MODIFICATION REQUEST:

Thomas Street Car Park, Chatswood

MP 09_0066 MOD 11

Secretary's
Environmental Assessment Report
Section 75W of the
Environmental Planning and Assessment Act 1979
September 2014

1 LEVELS 22-24 FLOOR PLAN
1:200

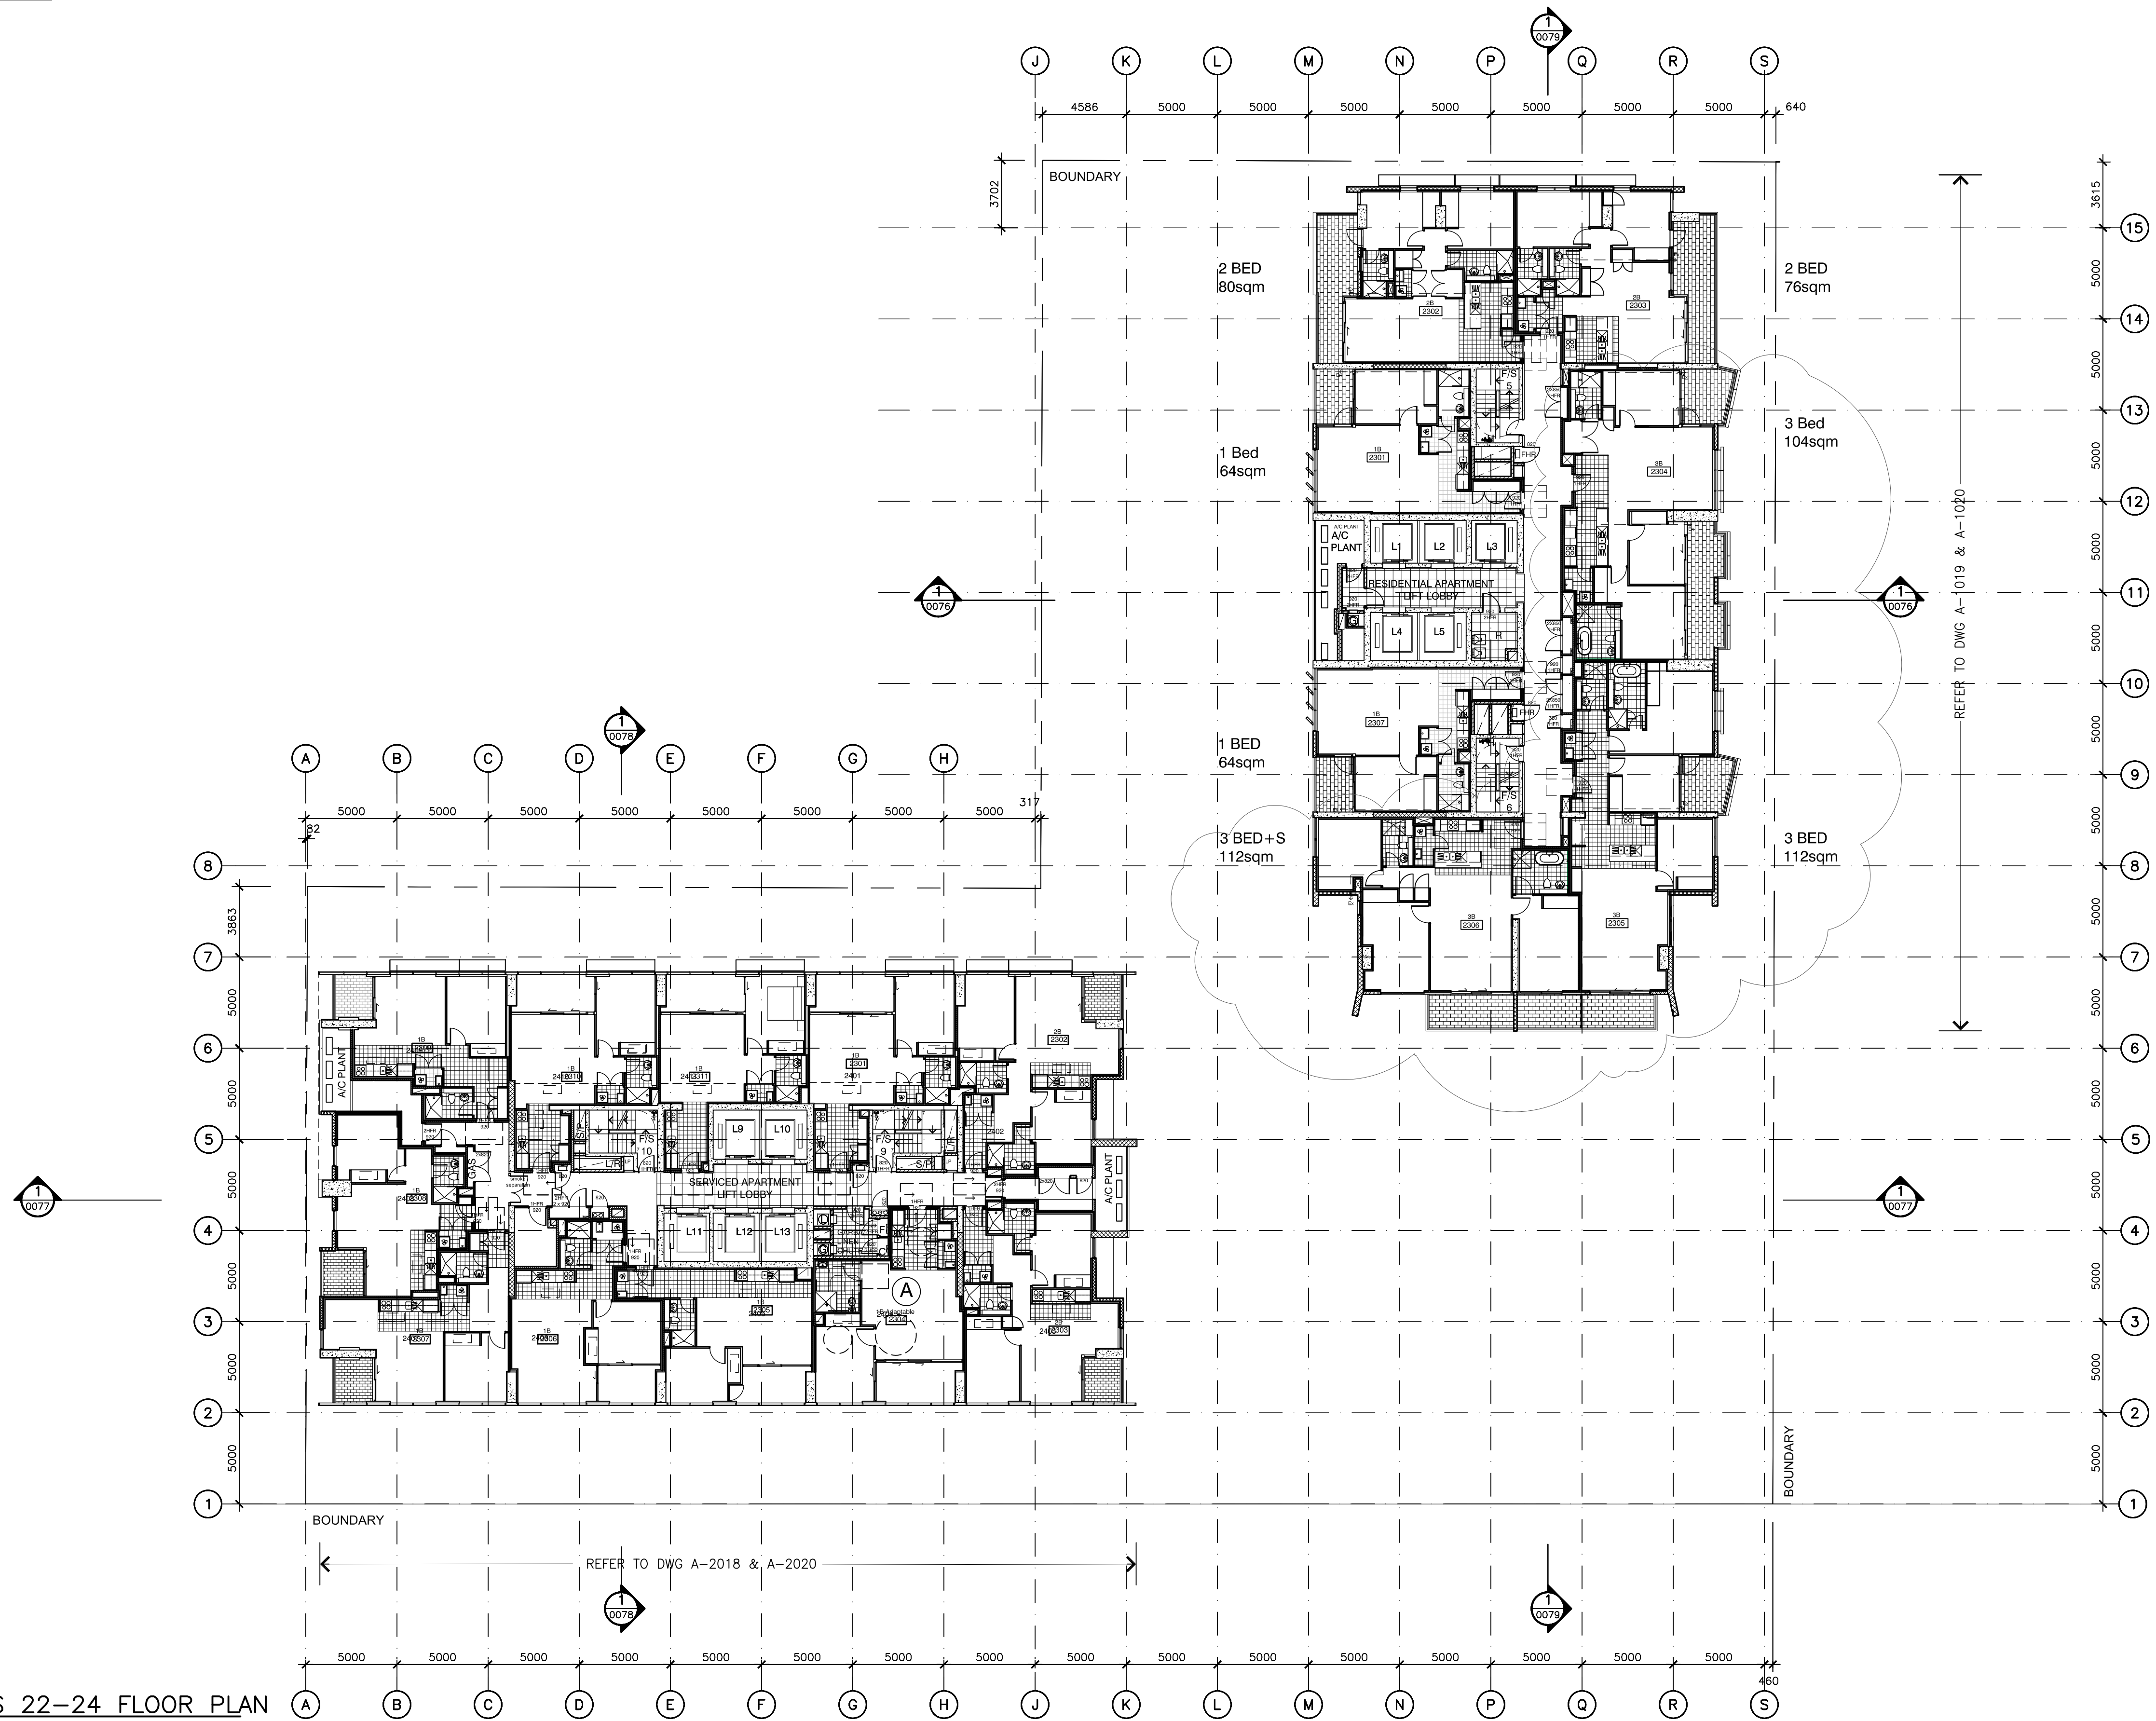
The proposal seeks to modify the layout of the southeast portion of Building 1 across Levels 22-36 to reduce the number of apartments from 286 to 271. On each level, 2 x 2 bedroom and 1 x 1 bedroom apartments would be replaced with 2 x 3 bedroom apartments. Minor internal and external alterations are also proposed.

The department supports the amendment and considers the revised layout will provide a good level of residential amenity consistent with *State Environmental Planning Policy 65 – Design Quality of Residential Flat Development* (SEPP 65) and accompanying *Residential Flat Design Code* (RFDC). In particular:

- the proposal will achieve at least 2 hours of sunlight to living and private open spaces of the south eastern corner unit, which provides a higher level of amenity than the previously approved south facing apartment in this location;
- the units will be naturally cross ventilated;
- the units will range from 104m² to 113m², which exceeds the 95m² minimum as referred to in the RFDC for housing affordability;
- despite the back of kitchens being more than 8 metres from a window (maximum is approximately 9 metres), the proposed apartment layout includes either a full width sliding door onto balconies or windows that will provide access to cross flow ventilation and also access to daylight; and

- each unit is provided with balcony spaces off bedrooms and living areas that are a minimum width of 2 metres and the majority facing east for solar access.
